Planning Application Ref: A/227/21/OUT

Location: Wilmington, Arundel Road, Angmering, BN16 4ET

Description of works: Outline application with all matters reserved (except access) for the erection of 7no. residential dwellings, vehicular & pedestrian access, with all matters reserved except for access. This application is a Departure from the Development Plan (Countryside)

Mark Warwick
Tree Officer / Greenspace

Drawing title: Root Protection Area Incursions Plan

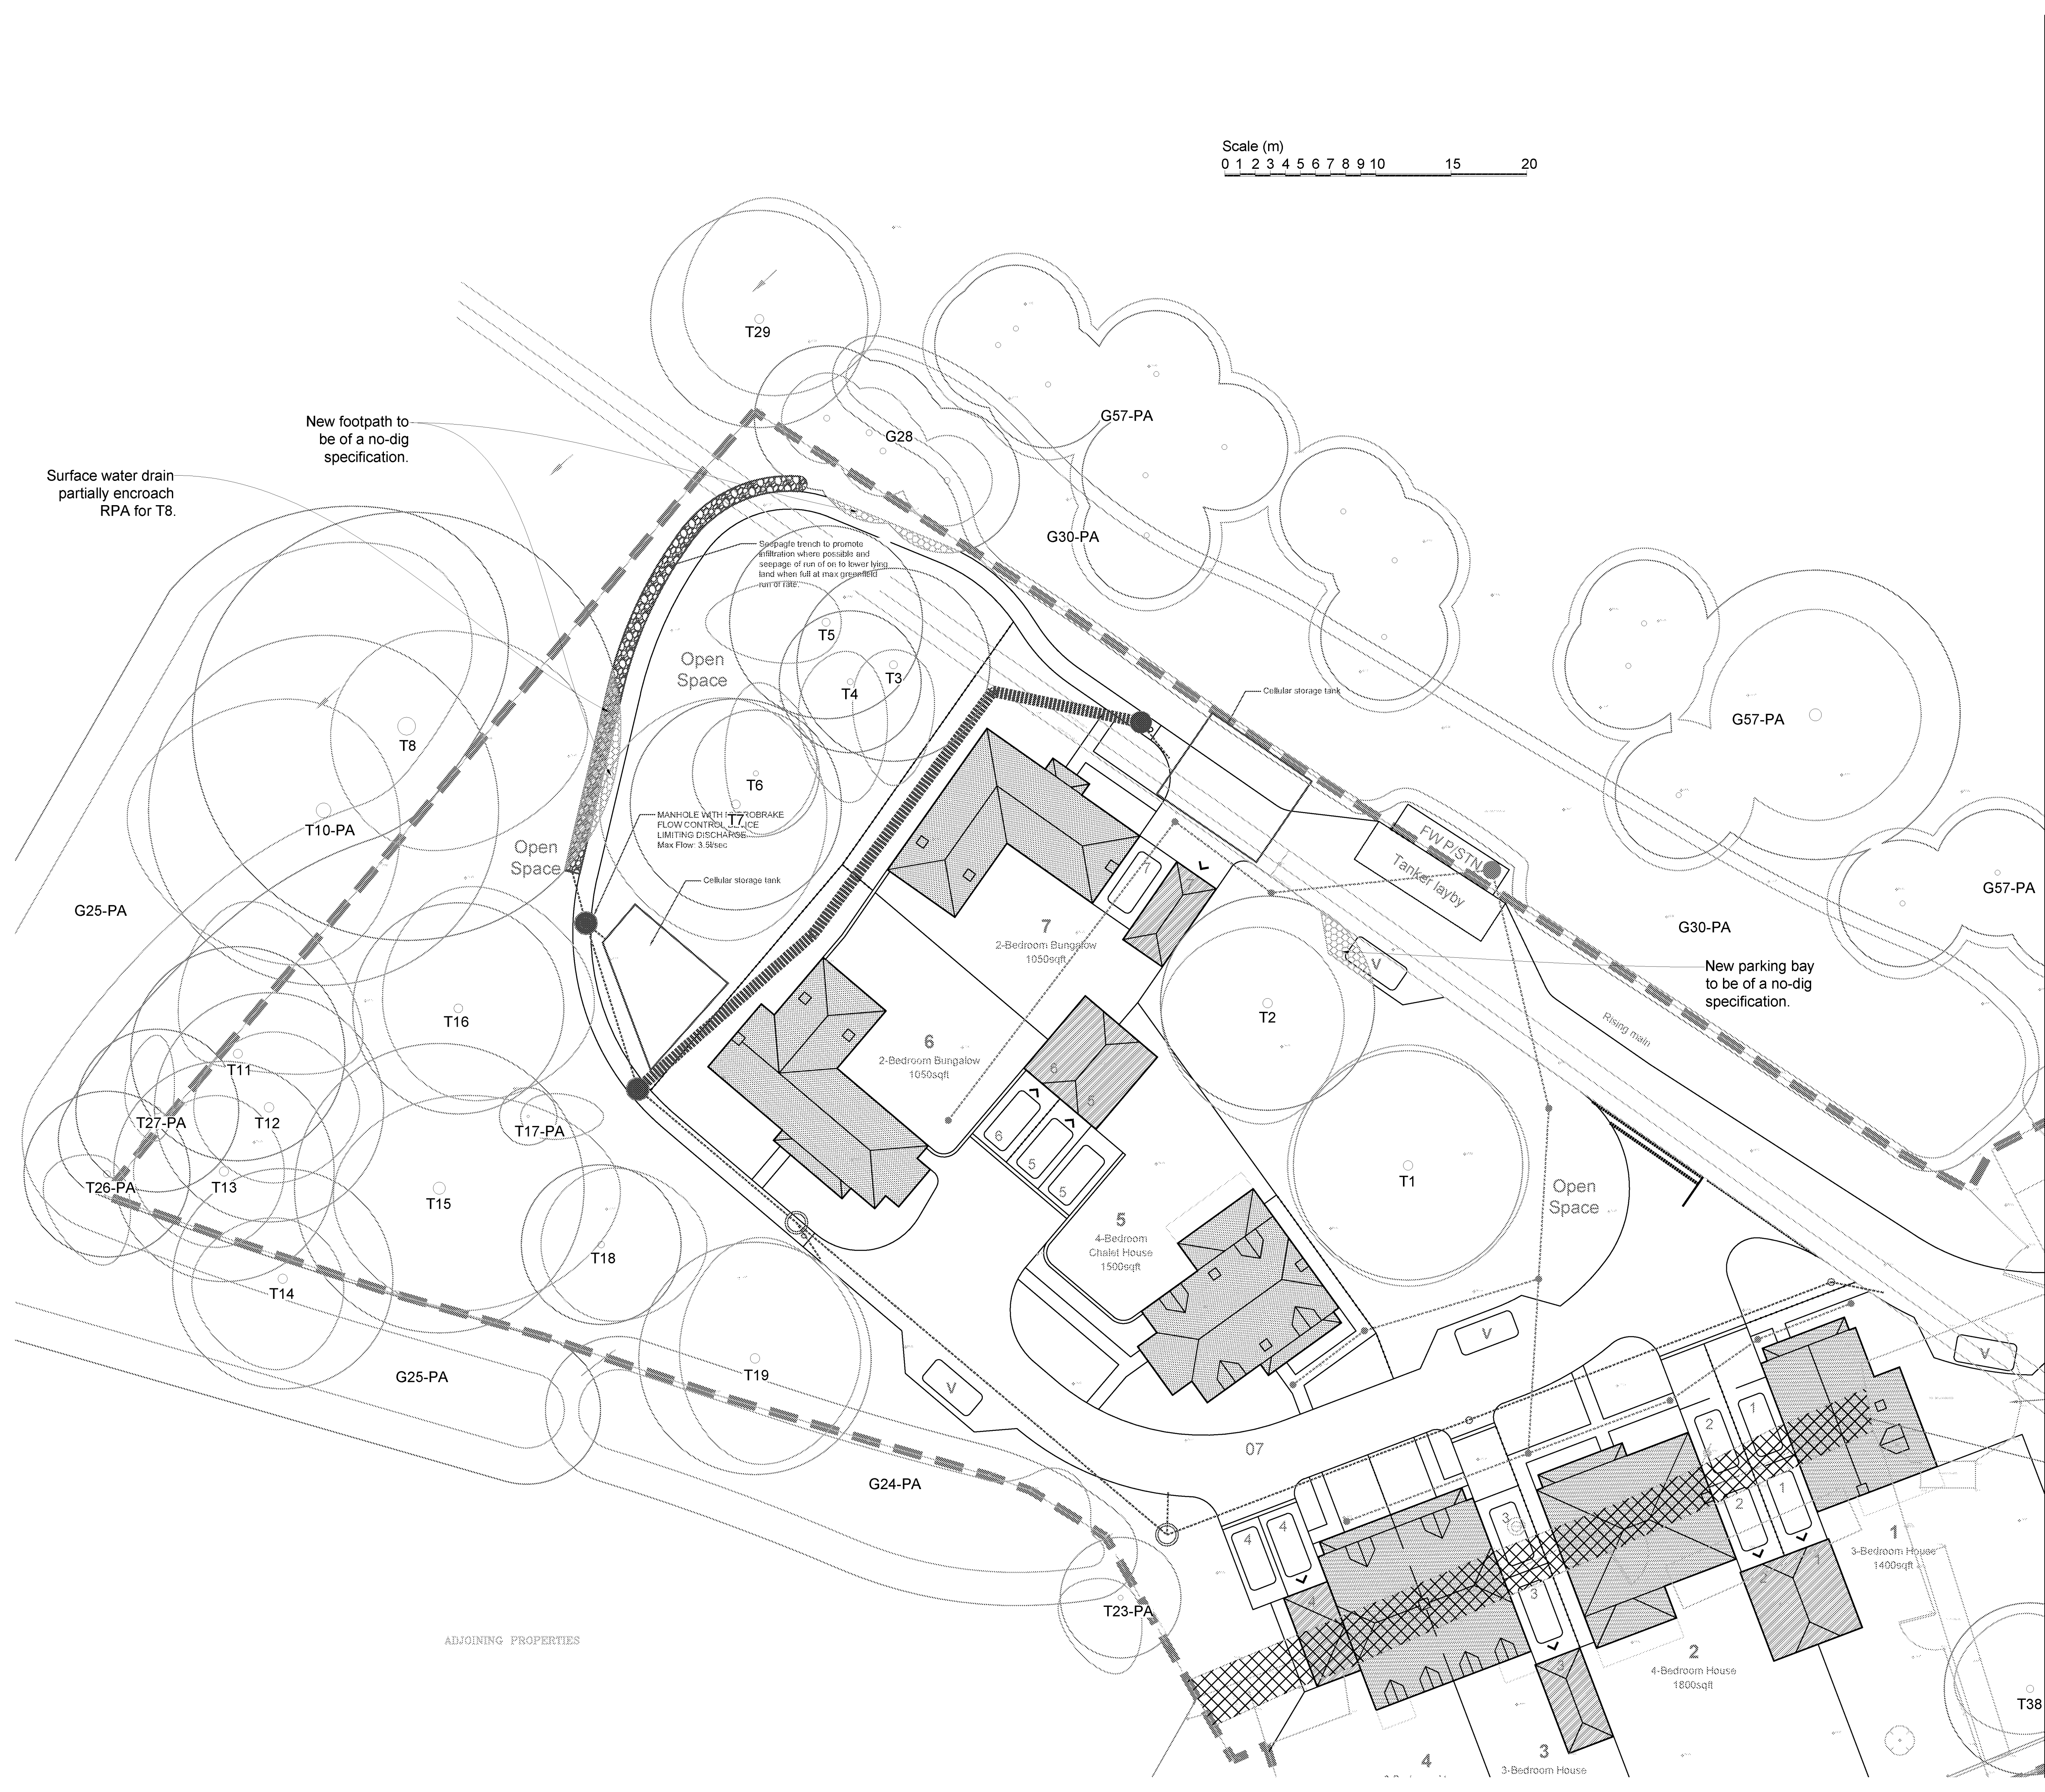
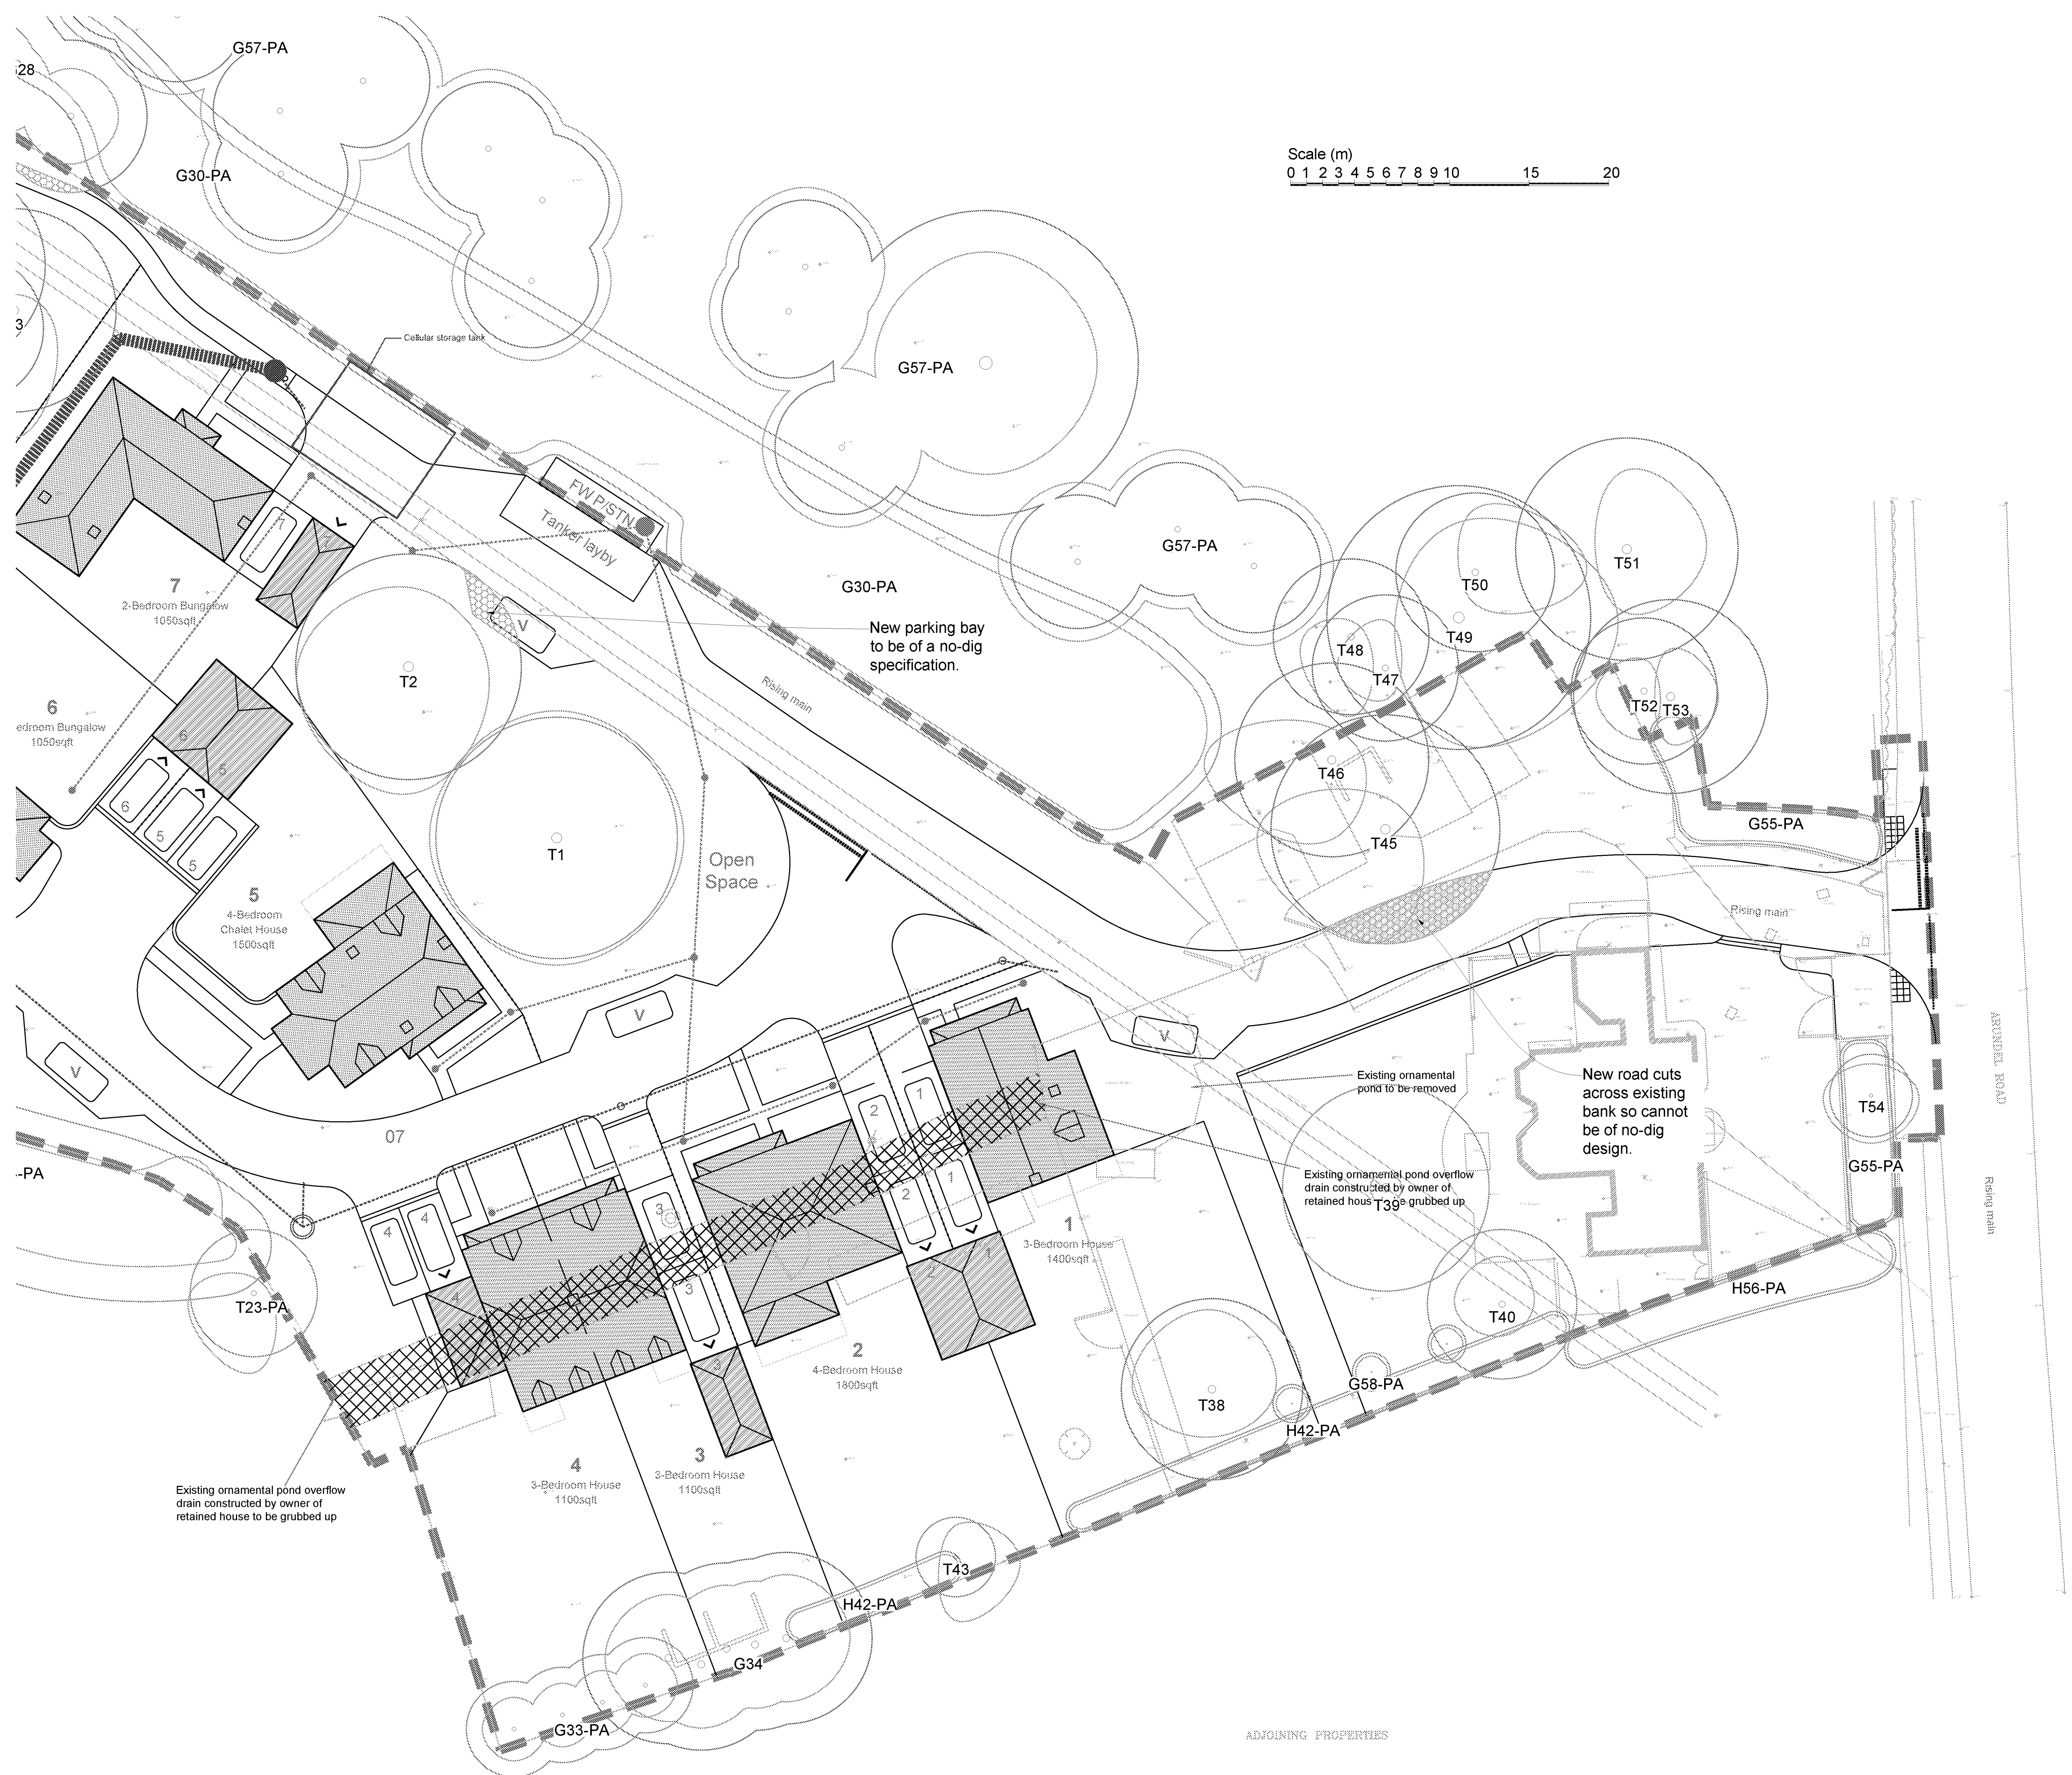
- There must be overriding justification for RPA incursion, not a presumption that BS5837:2012 – Trees in relation to Design, Demolition and Construction promotes activity in the RPA. It does not. It presents a range of options to consider, where such incursion is unavoidable or where no reasonable alternative exists. A layout that does not follow these principles should be resisted.

- I draw attention to the nominal root protection areas (RPA) of retained trees and their growth potential as obvious constraints to the siting of any SUDS (e.g., attenuation pond, swale) or introduction of subterranean utility apparatus. The provision of appropriate buffer/easement around such features must also take into account that growth potential (roots), to limit the risk of damage occurring during future maintenance of the same from compaction of soil.

Appendix 7: Tree Protection Fencing Specification

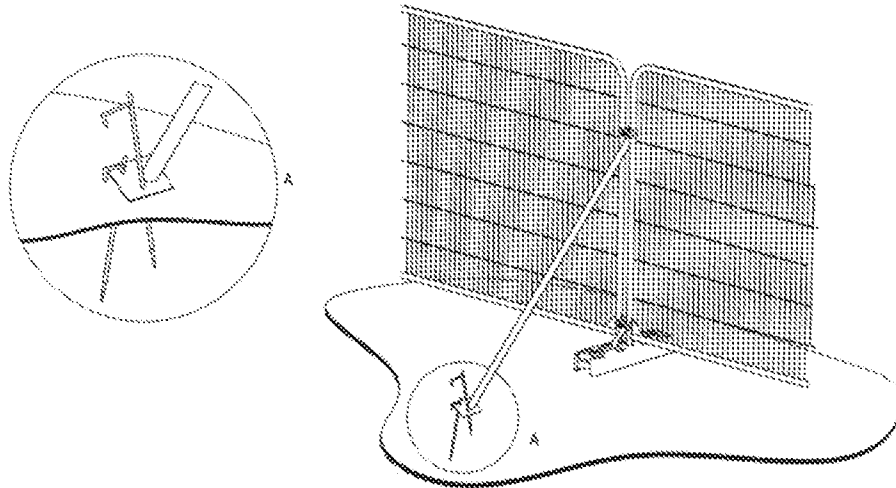
- The AIA/MS Report promotes a specification for Tree Protection Fencing in paragraph 3.4.2. (p12). It states: *'The specification for tree protection fencing shall be metal welded mesh panels in concrete or rubber feet..... (refer to Appendix 7)'*. That specification will provide 'fit for purpose' protection at the majority of Construction Exclusion Zones, although I would request a higher specification (around T1 & T2 for example) where retained trees are isolated within the construction area. For clarity, I would expect to see those mesh panels mounted on a rigid scaffold framework supported by back-stays and vertical poles at appropriate intervals and driven a minimum 600mm into the ground – (as per Figure 2, BS5837:2012, *Default specification for protective barrier*).
